Electorate office

17 December 2010

**Scottish Hospital - 2 Cooper St Paddington
MP10_0016 - Seniors Housing and Care Facility**

STEPHEN STREET ELEVATION

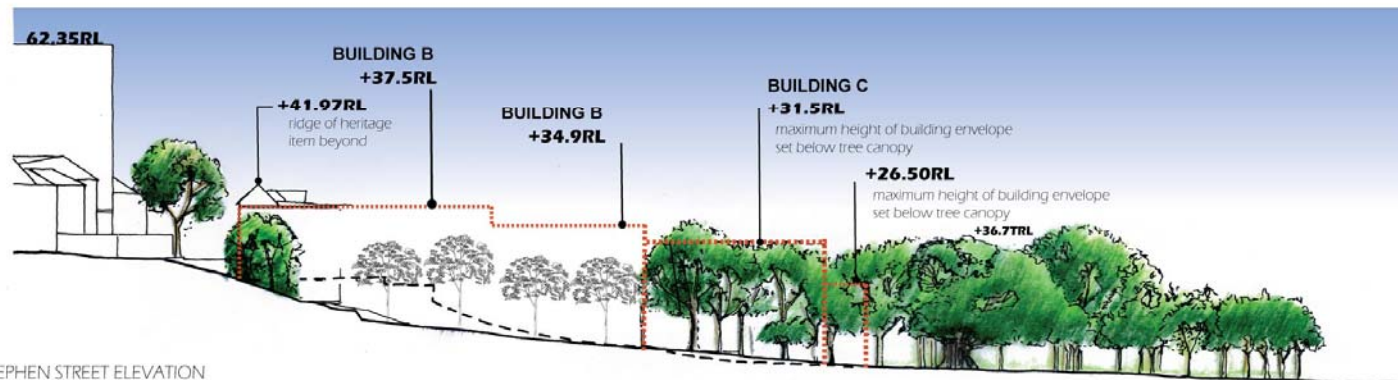
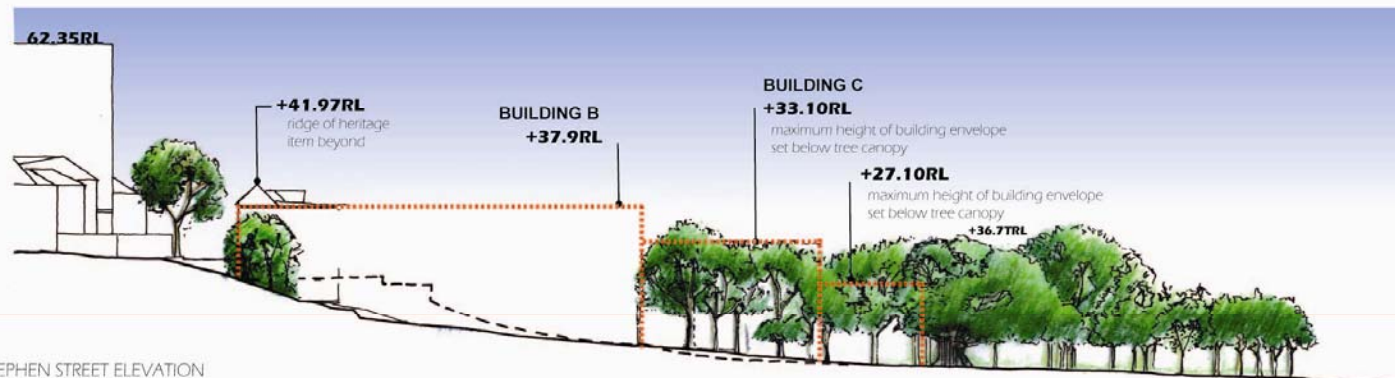
The proposal includes a nine storey building with up to seven storeys visible above street level on Brown Street, and a six storey building on Stephen Street. I share residents' concern that these heights are inconsistent with Paddington's Victorian heritage, the Woollahra LEP, and the Paddington Heritage Conservation Area Development Control Plan.

Residents are concerned that setbacks are inadequate for the scale of the proposal, particularly on Stephen Street where they are as little as 2.5 metres. Residents also request a larger setback for the nine storey building on Brown Street.

Stephen Street is a residential street and should not be widened to accommodate additional traffic.
